CITY OF PORTLAND, MAINE
Department of Planning and Urban Development
Building Inspections Division

Issued to: Rebeco LLC/Portland Food CO-OP

Location: 56 Hampshire St.

Job ID: 2011-03-529-ALTCOMM

A1.2

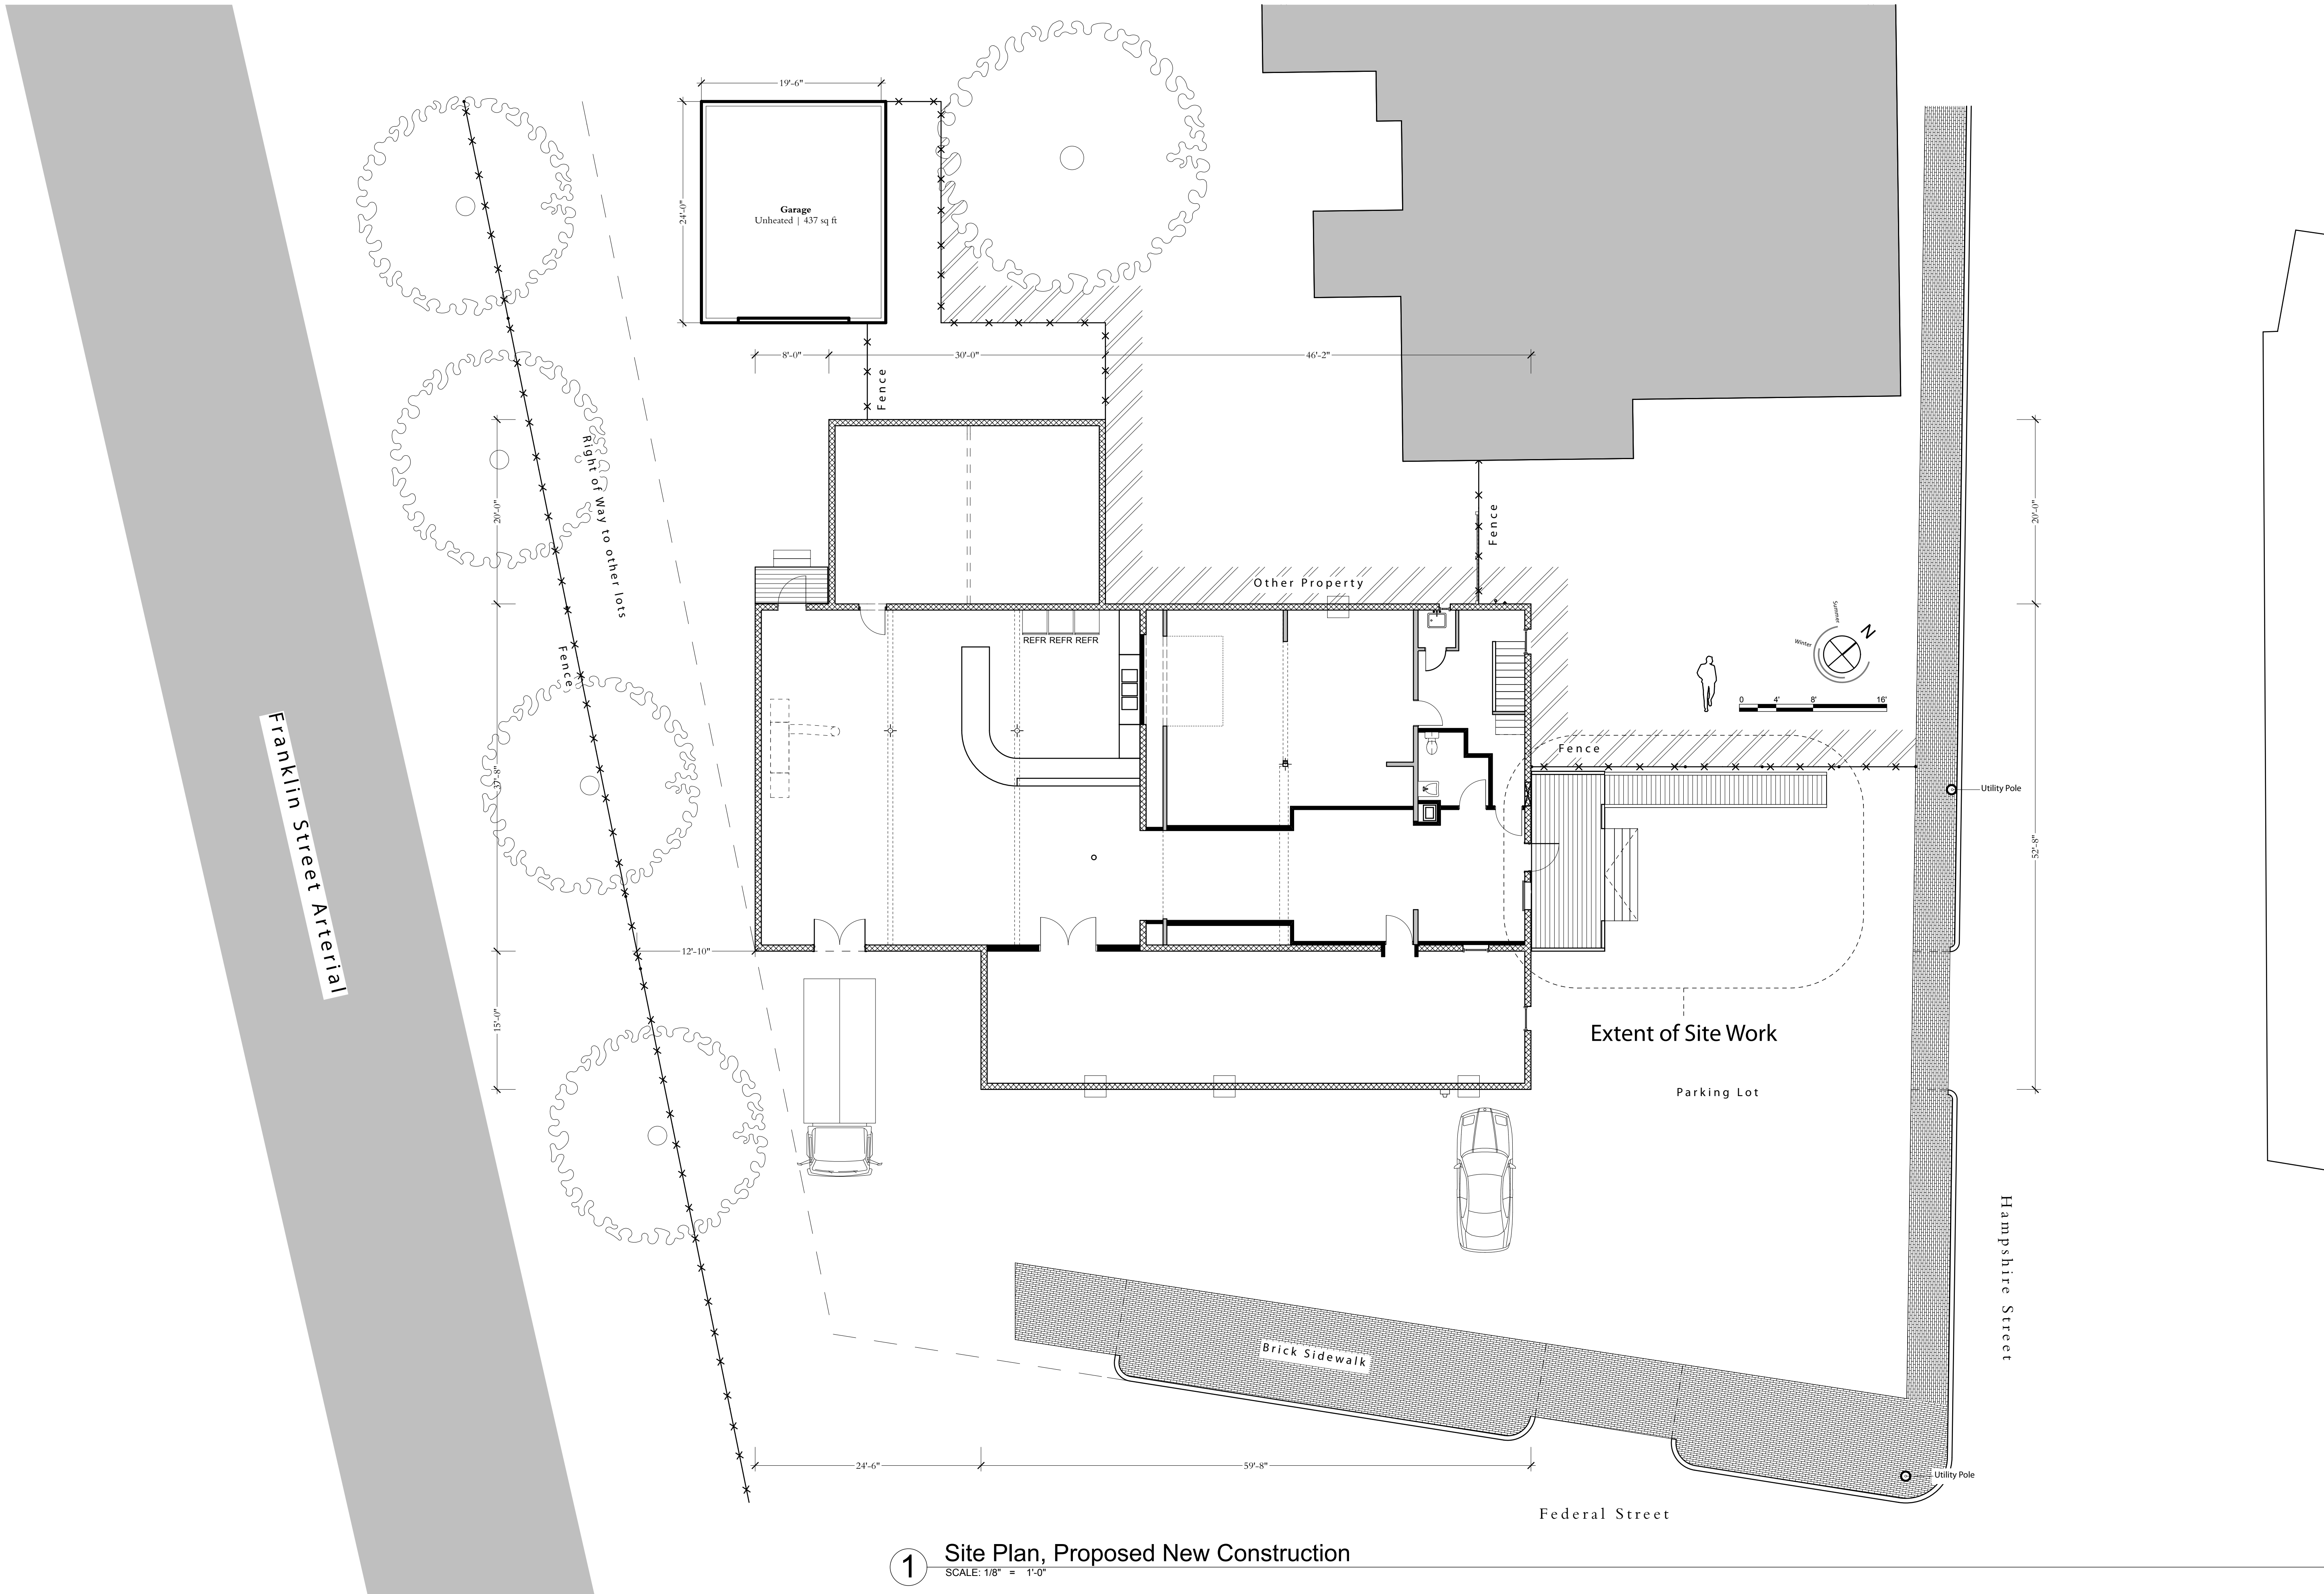
Yes, if you give me an updated plan showing the two exterior decks removed, I can pass the permit on for further review at this time. You will need to come in later with a separate application to build the two exterior decks you want.

① I need a site plan showing property lines to measure setbacks & compliance

② This requires a site plan review
